From: planning@welhat.gov.uk
To: [Planning Comments \(Shared Mailbox\)](#)
Subject: New comments for application 6/2019/3024/MAJ
Date: 30 December 2019 11:04:29

New comments have been received for application 6/2019/3024/MAJ at site address: 29 Broadwater Road
Welwyn Garden City AL7 3BQ

from Kate Harwood conservation@hertsgardenstrust.org.uk

Drawing Title
External Materials Elevations

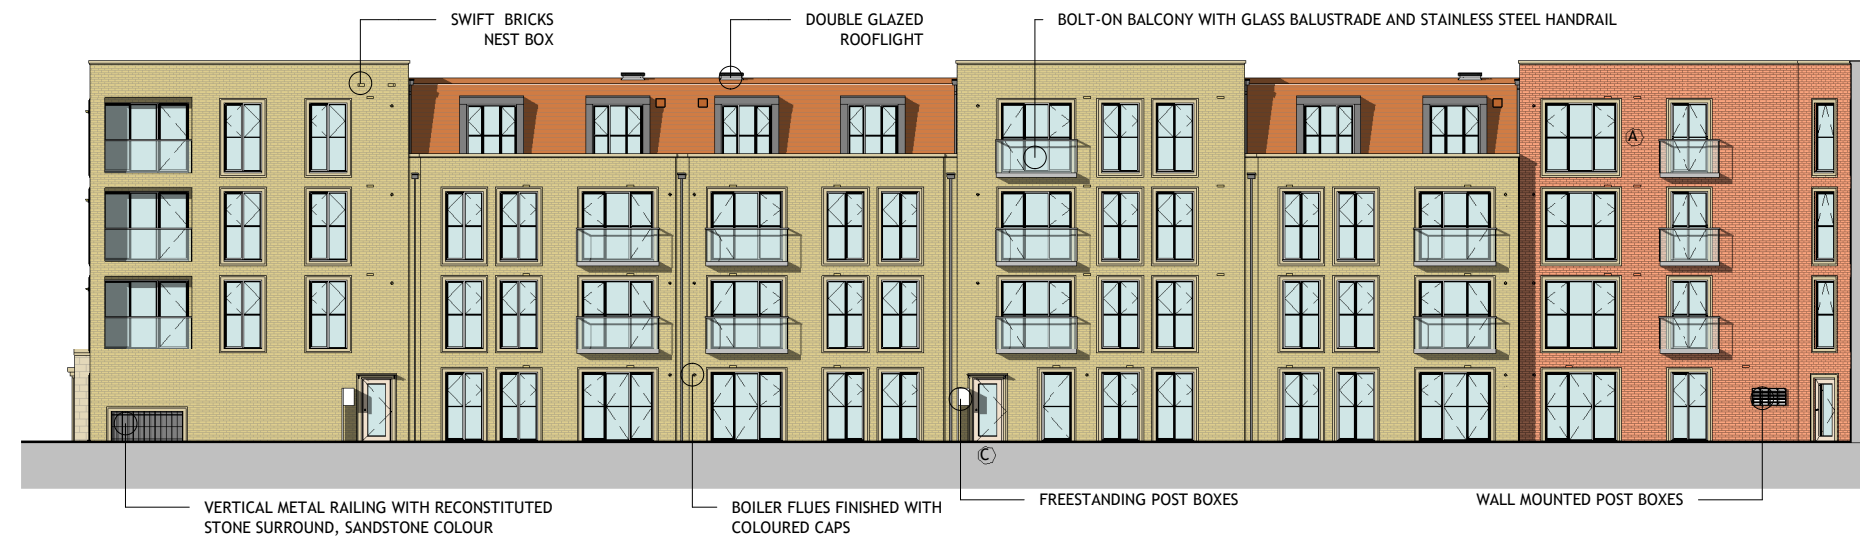
We are unaware of a WHBC overall design statement for the redevelopments along Broadwater Road which would ensure a high-quality appearance referencing the original buildings. The choice of materials - orange and buff bricks, for this development, would seem to be out of keeping with the original finishes on the Shredded Wheat factory, Roche buildings and others. Although the commercial and residential areas of Welwyn Garden City do have such guidance, the industrial areas to the east of the railway line are in danger of losing their visual coherence and thus any link with the Garden City Concepts of the early town.
